Re: **Planning and Community Development Review of VR-17-01 – Academy Village, Filing No. 3, Third Submittal – Comment Response**

This letter is in response to submittal comments dated April 19, 2018. Responses by JR Engineering are represented by **JR Response**.

ACADEMY VILLAGE FILING NO. 3  
UTILITY SERVICE PLAN

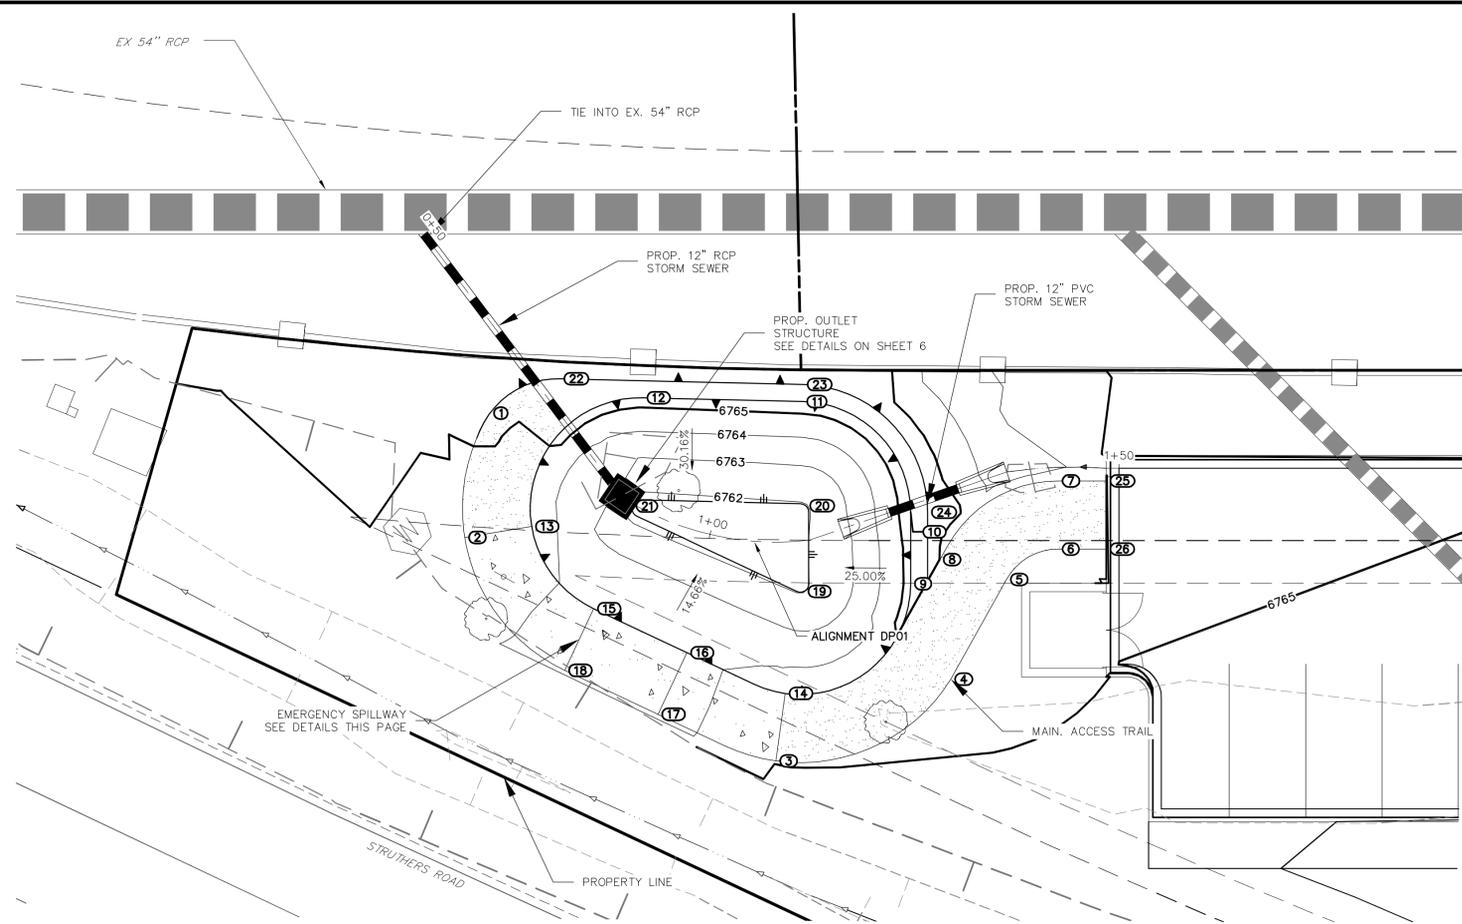
1. Note: the Site Development Plans were used for reference, but not reviewed as construction plans for this plat since there are no public improvements.
2. Provide a separate set of utility construction plans for the utilities crossing Struthers Road, including profiles, details, etc., and the utility district's signatures. Note: approval of these plans will allow for issuance of a work-in-the-right-of-way permit (with separate fee) from EPC Department of Public Works. Partially resolved; see redlines. **Partially resolved; per previous redlines, delete the County signature block from the utility service plan sheet.**

**JR Response: Addressed. County signature block has been removed. You will note that the County signature block, and the owner signature block have been "X'd" out, and not removed from the Utility Service Plan set since Donala Water and the Fire Department have already reviewed and approved (signed) these plans. The signature blocks on those signed plans have been "X'd" out.**

ACADEMY VILLAGE FILING NO. 3  
 POND GRADING PLAN  
 SHEET 5 OF 6  
 JOB NO. 25123.00

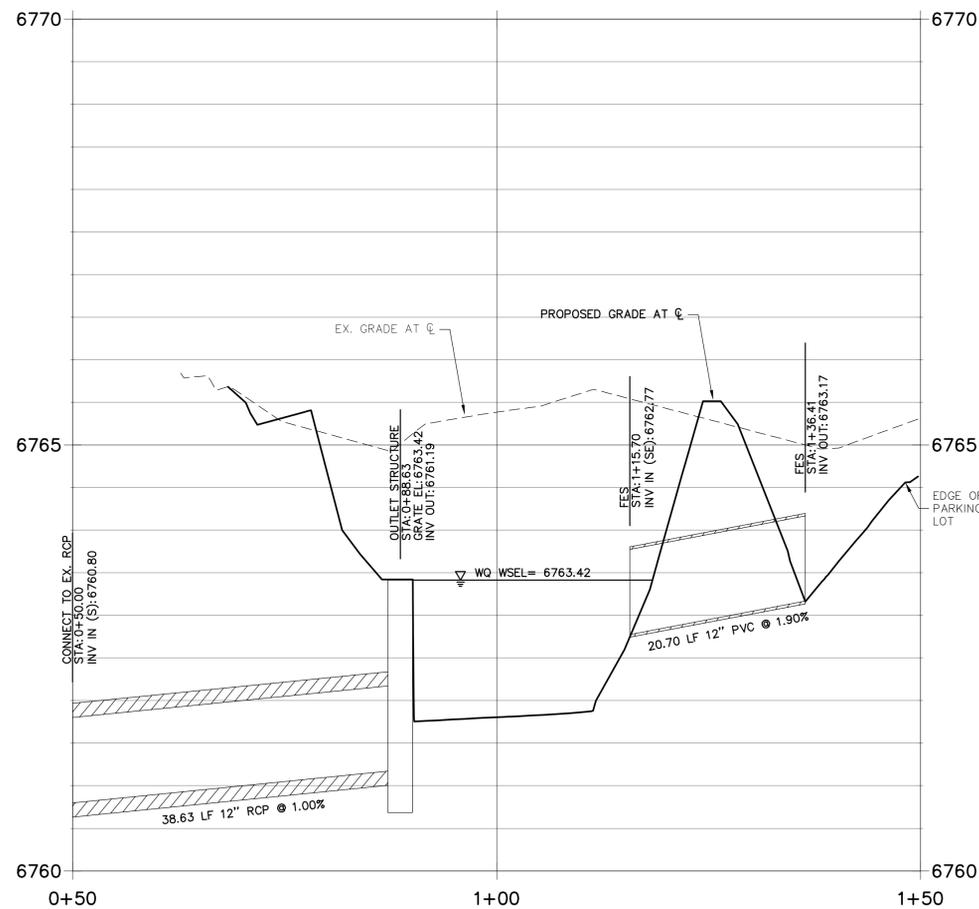
3. Provide complete WQCV pond design including emergency overflow path. Unresolved (see comment #2). **Unresolved**

**JR Response: Addressed. The WQ pond, outlet structure, and spillway are shown in the plans.**

ACADEMY VILLAGE FILING NO. 3  
OUTLET STRUCTURE DETAILS

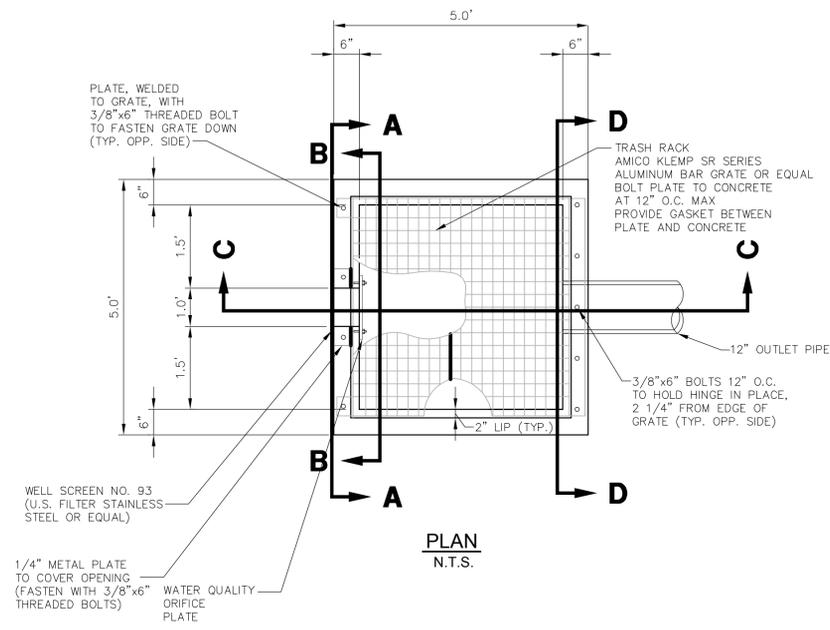
1. Resolved
2. Ensure that all checklist items highlighted in blue have been provided. Since the water quality pond/BMP is being provided, additional detail is needed in the drainage letter report. Partially resolved; provide complete details for the WQCV BMP in the drainage report and plans. ~~Please re-evaluate the proposed type of BMP being used -- per DCM2~~

**JR Response: Addressed. Details related to the WQ pond are included in the drainage letter. The WQ pond and outlet structure details have been provided.**
